Reference: H03-1030-25
Proposal: Demolition of existing garage conversion & erection of side extension
Location: 7 Everard Road Tongue End Spalding
Applicant: Mr & Mrs Campbell

Acceptance of Amendment Number 1

**25.021 - AA033 - 2.0 - A02**

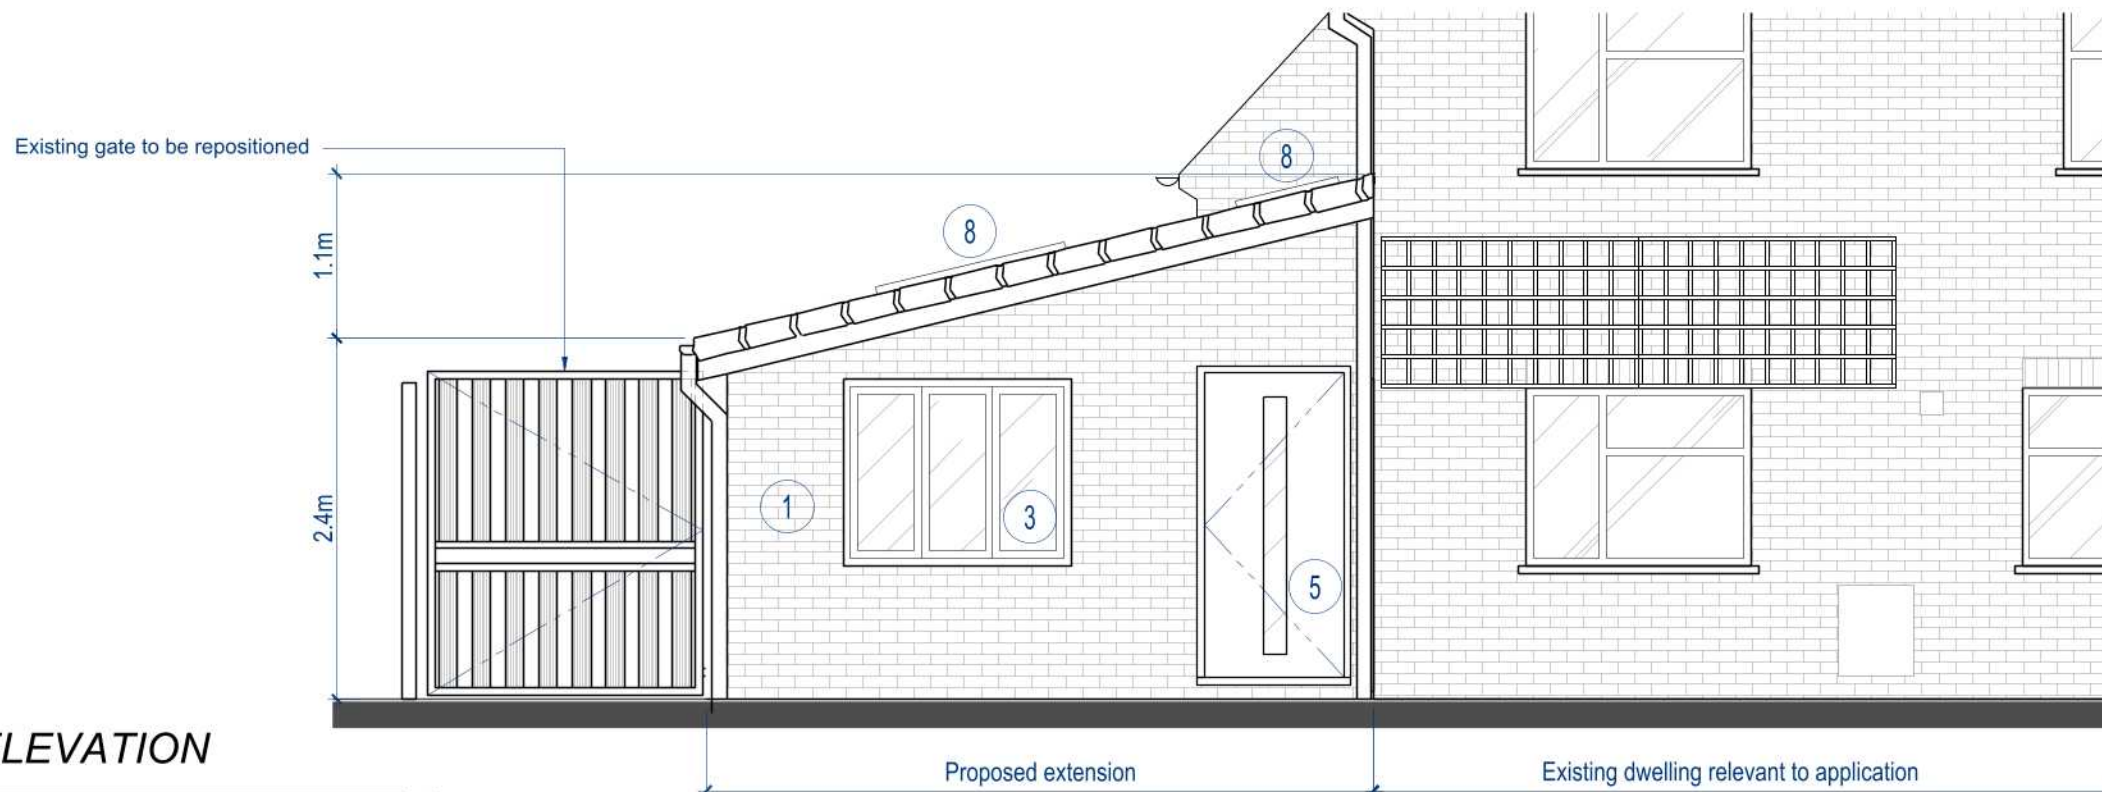
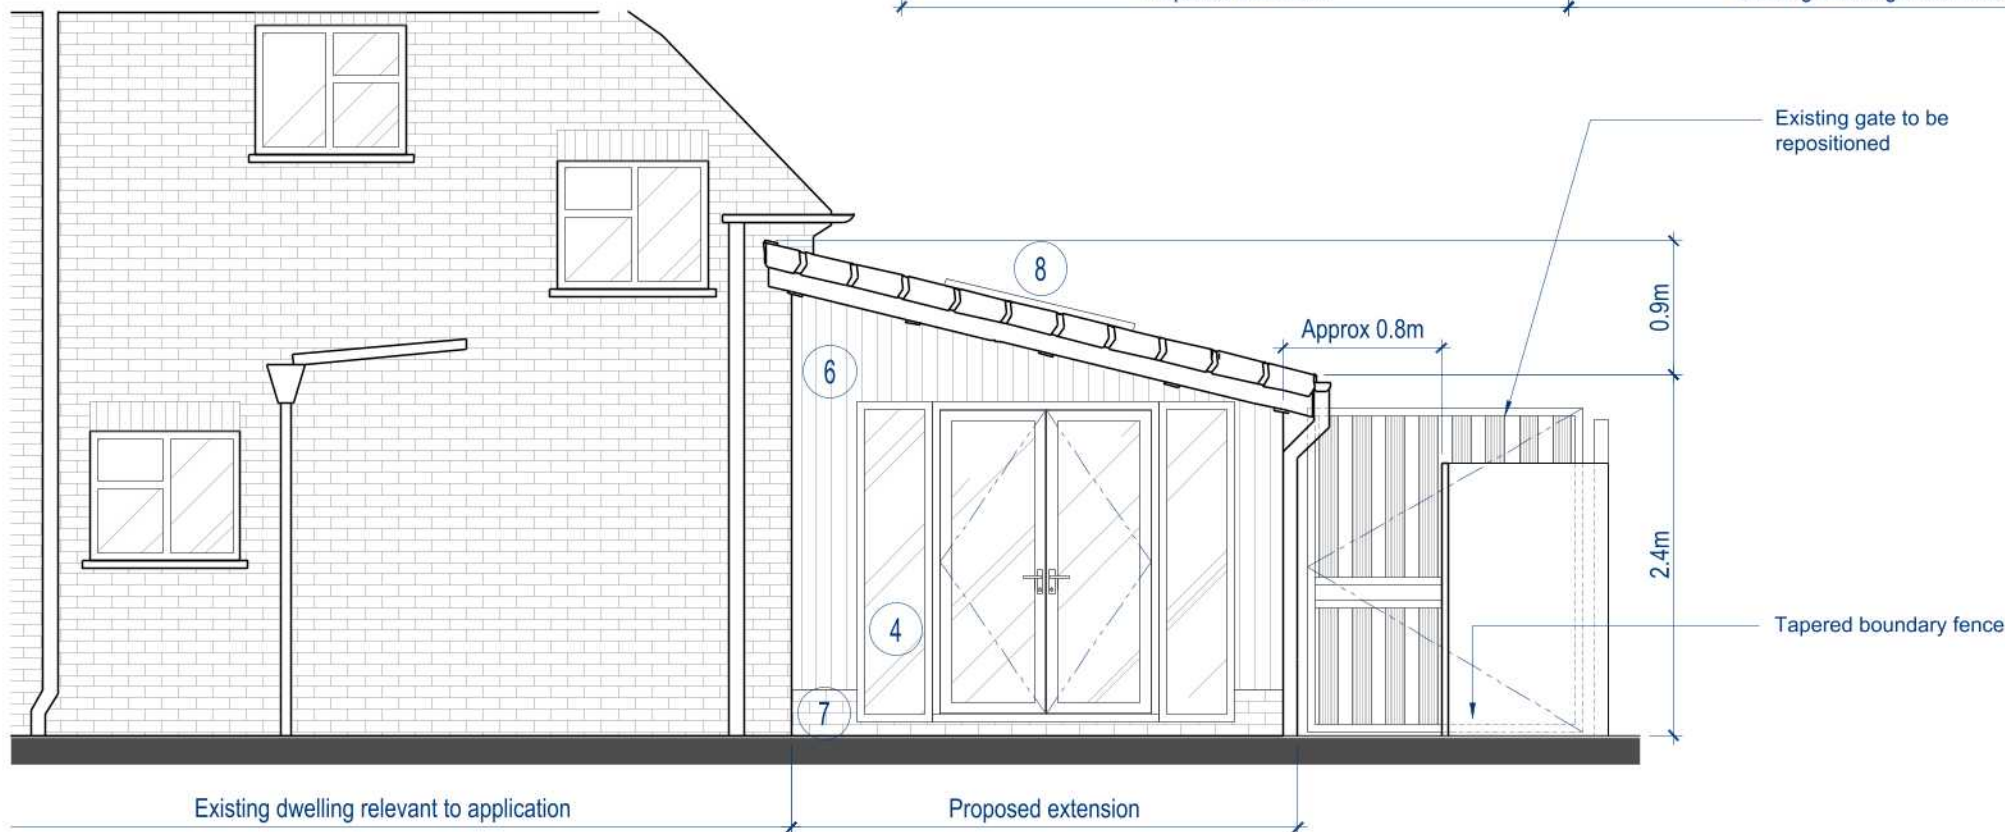
Materiality & design form amended following consultation with LPA. Amendment to principle facade finish changed to brickwork & roof finish changed to tiles & ridge height increased
